WEST SUSSEX COUNTY COUNCIL CONSULTATION

TO:	Arun District Council - FAO: Amy Myer
FROM:	WSCC - Highways Authority
DATE:	25 October 2021
LOCATION:	Land North of Highdown Vineyard (Formerly McIntyre Nursery) Littlehampton Road Ferring BN12 6PG
SUBJECT:	FG/142/21/PL Change of Use of the land for the storage of building materials; 2 no. proposed storage containers and 2.4m high Pallisade or Paladin Fencing (coloured green) to perimeter with access gates. This application is a Departure from the Development Plan.
RECOMMENDATION:	No Objection

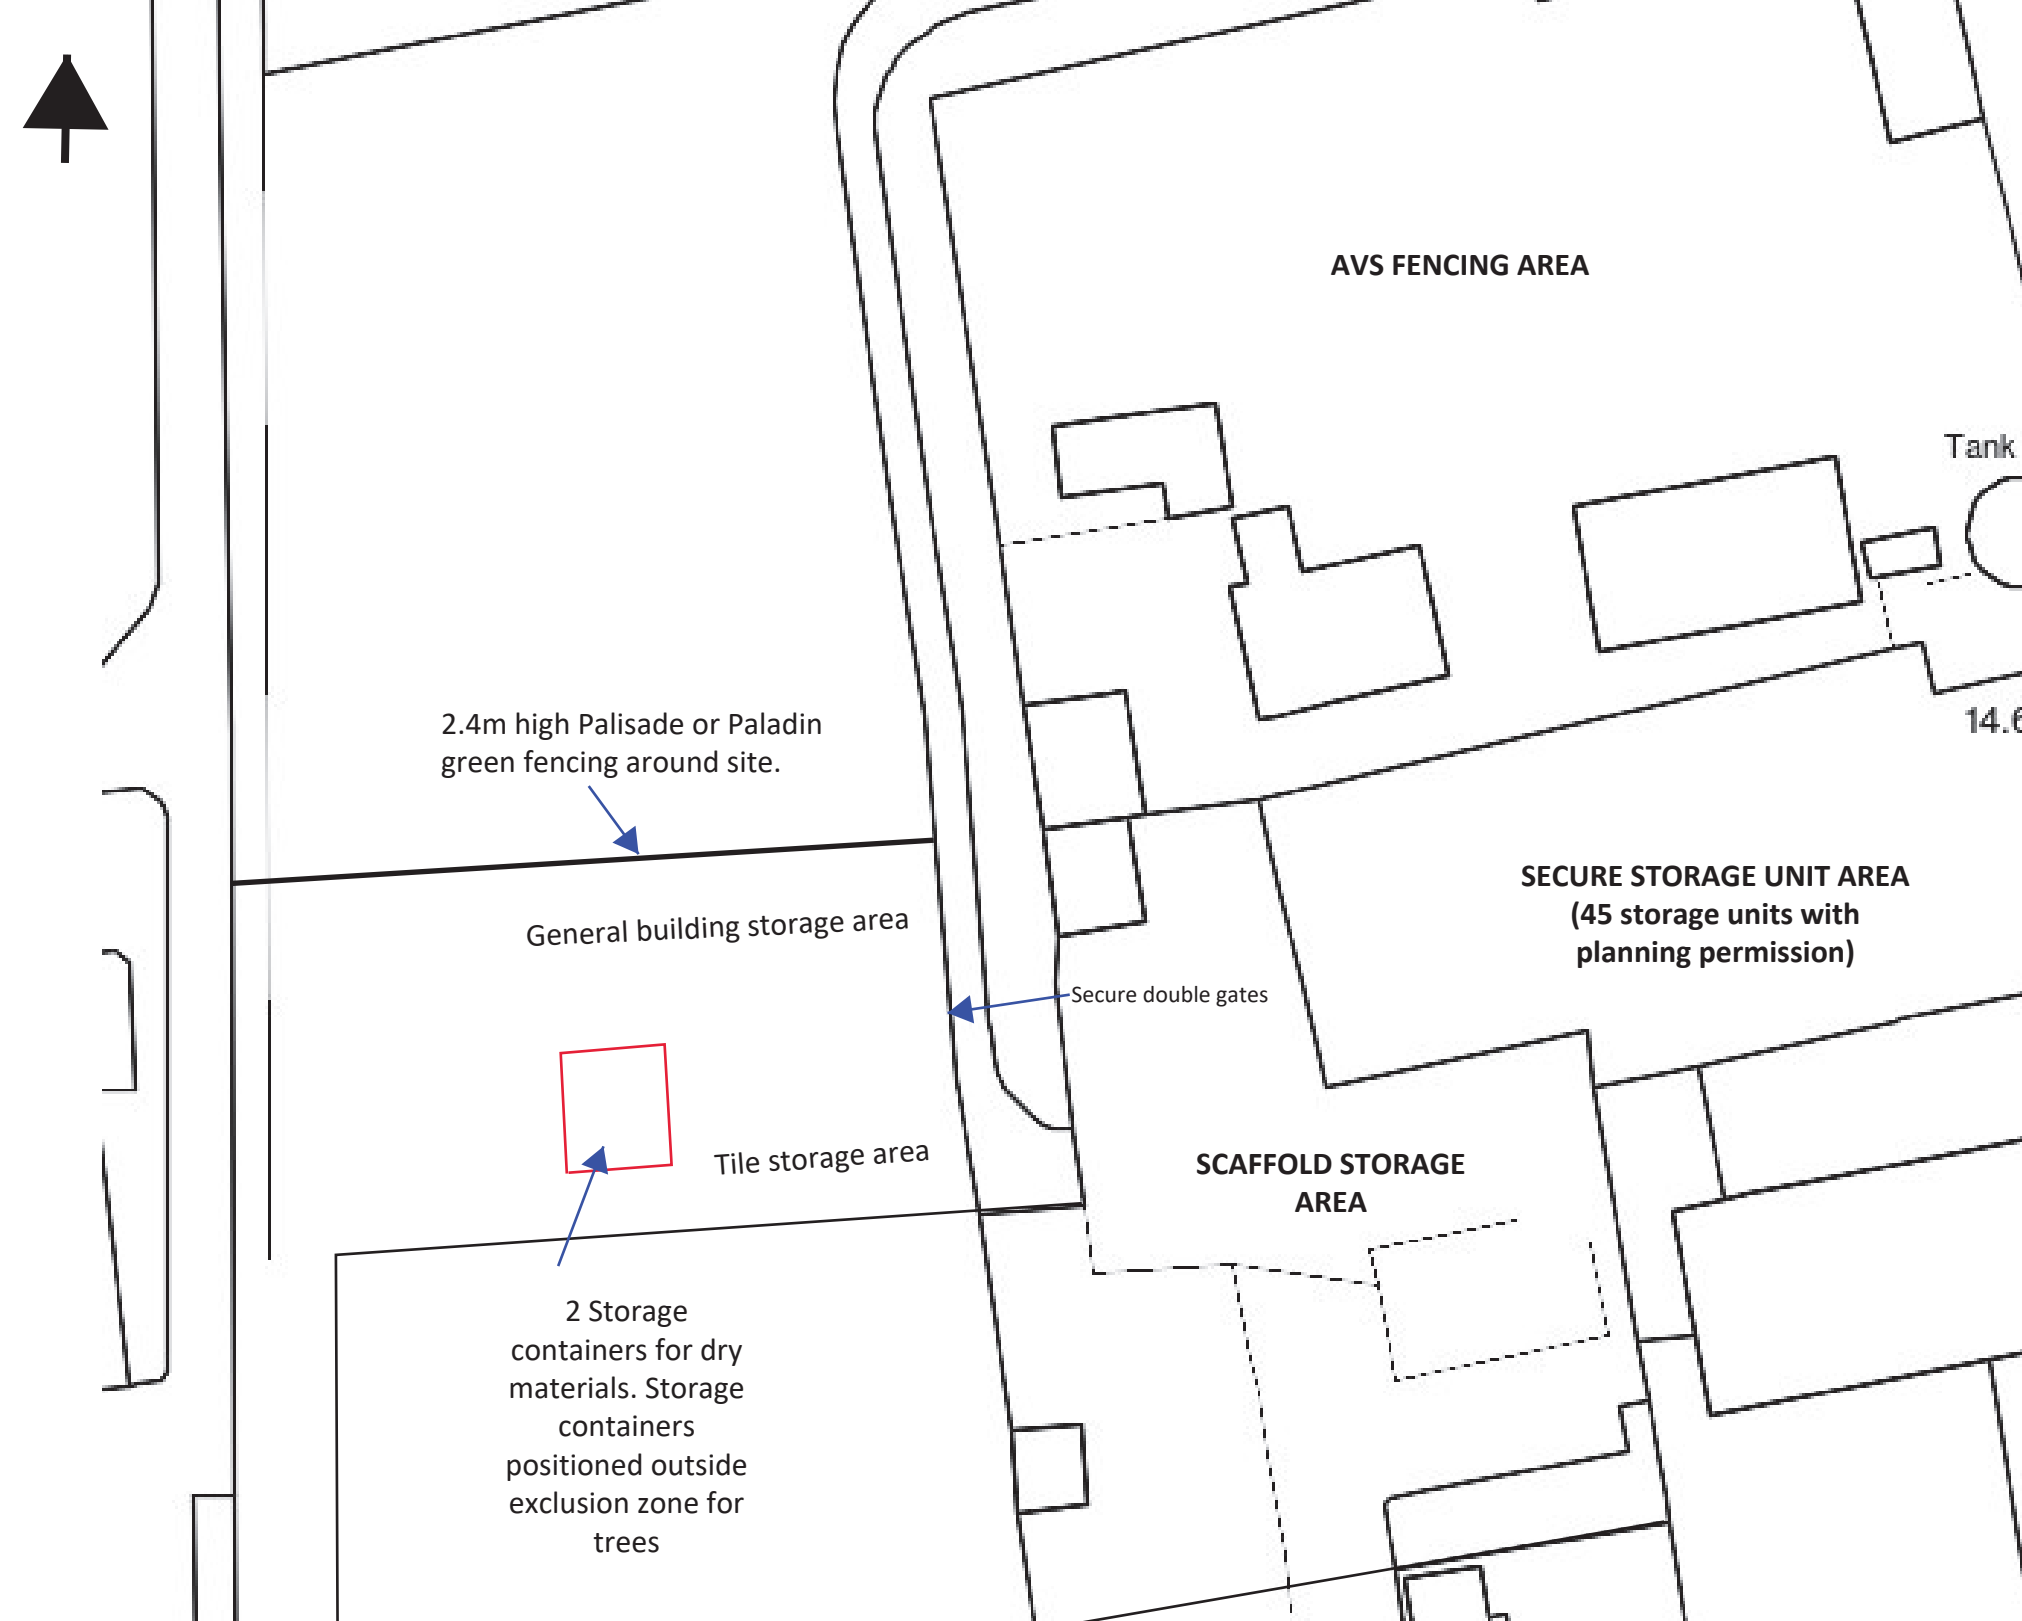
The plans do not indicate where vehicles will park and turn within the site, though it appears there is ample space for this. The Local Planning Authority (LPA) may wish to secure a condition of details to be provided for this aspect.
